Project ID: The Old Ticket Master's Office, Hill Street, Elsecar, Barnsley, S74 8EL
Doc Ref: 02974-550100
Doc Type: Response to Environmental Health Comments

Barnsley MBC Comments

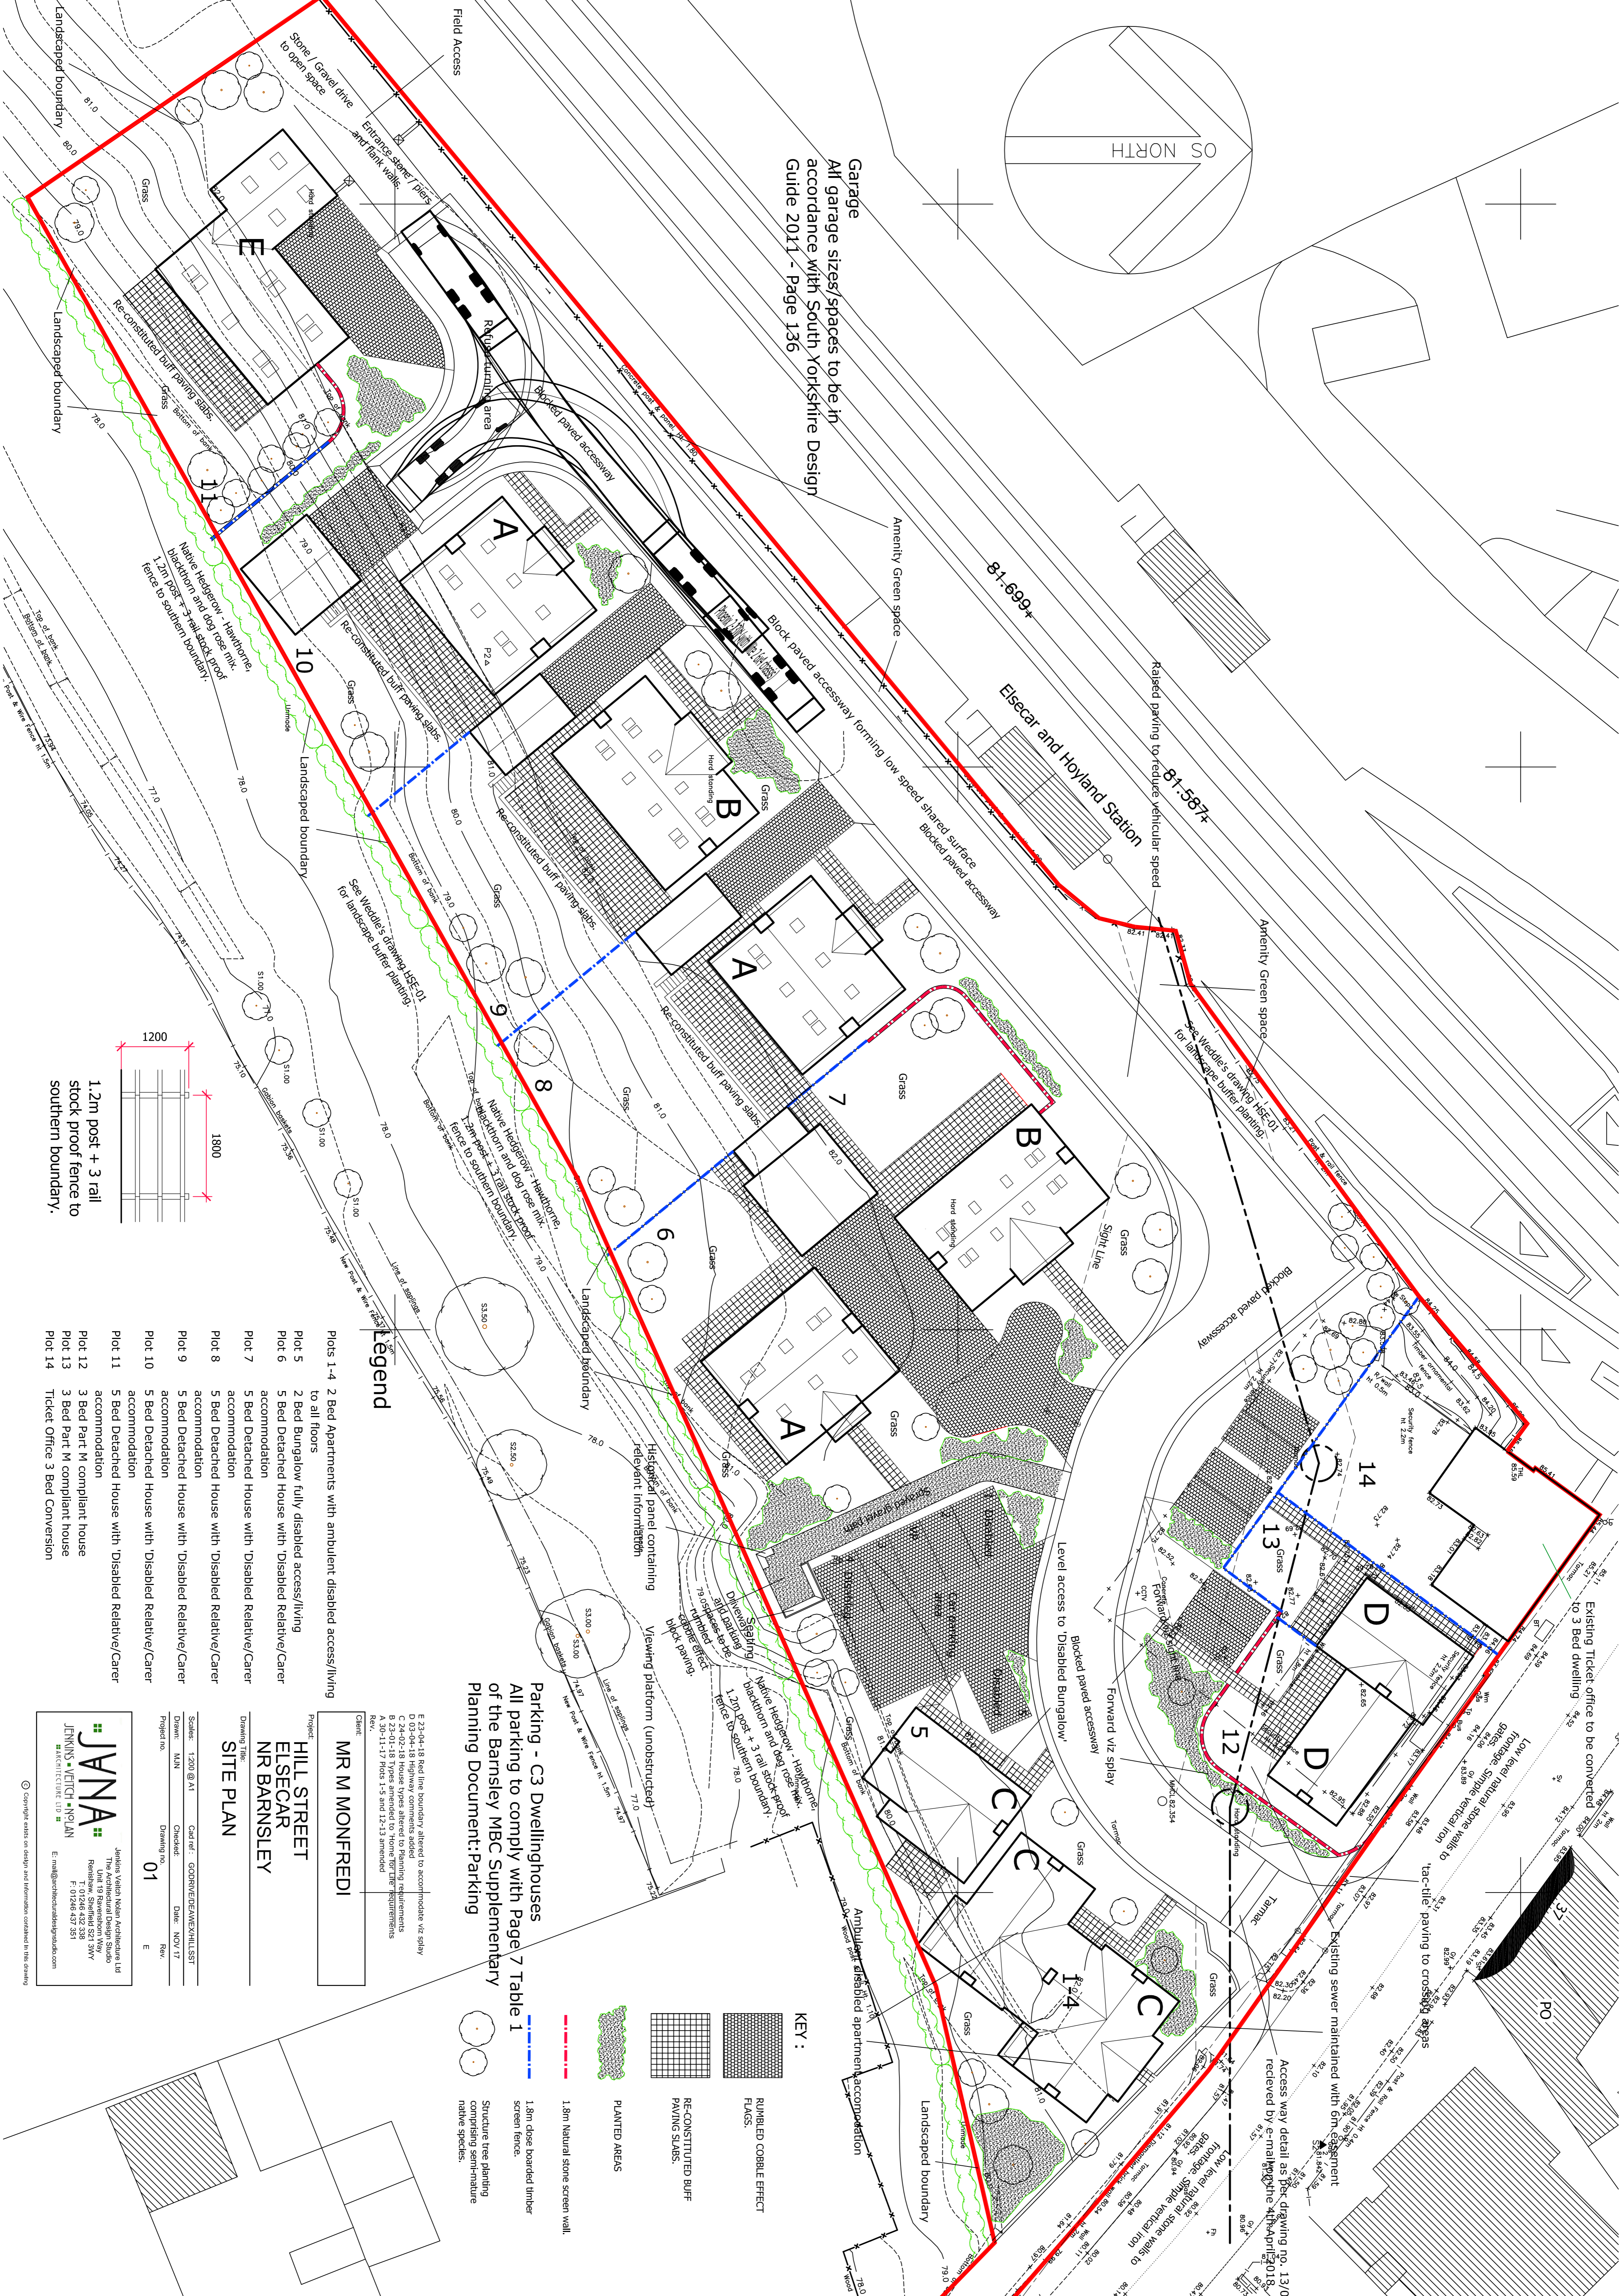
With regard to noise levels in the gardens I believe a figure of 50dB LAeq is a more suitable limit as this allows for some uncertainty that there may be in the measurements results (none provided in the report). I would therefore like to see information detailing what the noise levels will be in each of the different plot's gardens, with acoustic barrier if necessary."

We understand that a 1.8m high acoustic fence is proposed to be provided along the western site boundary with the railway. The fence shall be of close-boarded construction as described in our report and shall extend from the existing ticket office building to the western corner of the development site.

As requested, the table below sets out the calculated sound levels from passing trains, and Hill Street traffic, in private garden areas. Calculations are based on the measured daytime sound levels at site and include corrections for distance and acoustic screening from the boundary fencing and intervening houses. As mentioned in our report, Plots 1-4 are flats and do not have gardens.

House Plot	Level dB LAeq,(0700-2300)	Distance to garden (m)	Barrier Attenuation (dBA)	Sound Level in garden (dBA)	Total dB LAeq,(0700-2300)
5	Railway - 51.8 at 16m	60	-7	39.1	47.7
	Road Traffic - 57.7 at 11m	40	-5	47.1	
6	Railway - 51.8 at 16m	50	-7	39.9	45.4
	Road Traffic - 57.7 at 11m	82	-5	44.0	
7	Railway - 51.8 at 16m	30	-7	42.1	46.4
	Road Traffic - 57.7 at 11m	74	-5	44.4	
8	Railway - 51.8 at 16m	50	-7	39.9	44.9
	Road Traffic - 57.7 at 11m	96	-5	43.3	
9	Railway - 51.8 at 16m	45	-7	40.3	44.5
	Road Traffic - 57.7 at 11m	116	-5	42.5	
10	Railway - 51.8 at 16m	45	-7	40.3	44.1
	Road Traffic - 57.7 at 11m	135	-5	41.8	
11	Railway - 51.8 at 16m	45	-7	40.3	43.7
	Road Traffic - 57.7 at 11m	160	-5	41.1	
12	Railway - 51.8 at 16m	39	-8	39.9	49.6
	Road Traffic - 57.7 at 11m	25	-5	49.1	
13	Railway - 51.8 at 16m	32	-8	40.8	49.7
	Road Traffic - 57.7 at 11m	25	-5	49.1	
14	Railway - 51.8 at 16m	23	-8	42.2	49.9
	Road Traffic - 57.7 at 11m	25	-5	49.1

The calculations show that daytime railway and Hill Street traffic noise levels are expected to be no greater than 50dB LAeq in the private garden areas. It can be seen that noise impact from road traffic is greater than that predicted from trains, although this is generally perceived as a more anonymous noise source. It should be noted that the measured and predicted ambient noise levels for the new house plots are relatively modest when compared to many residential and urban areas, i.e. the daytime ambient sound level at Location 1, with line of sight to the railway and station platform is 54dB LAeq,16hr. Indeed, there are existing properties in the vicinity of the site that will experience equivalent, or greater, exposure to rail and/or road traffic noise.
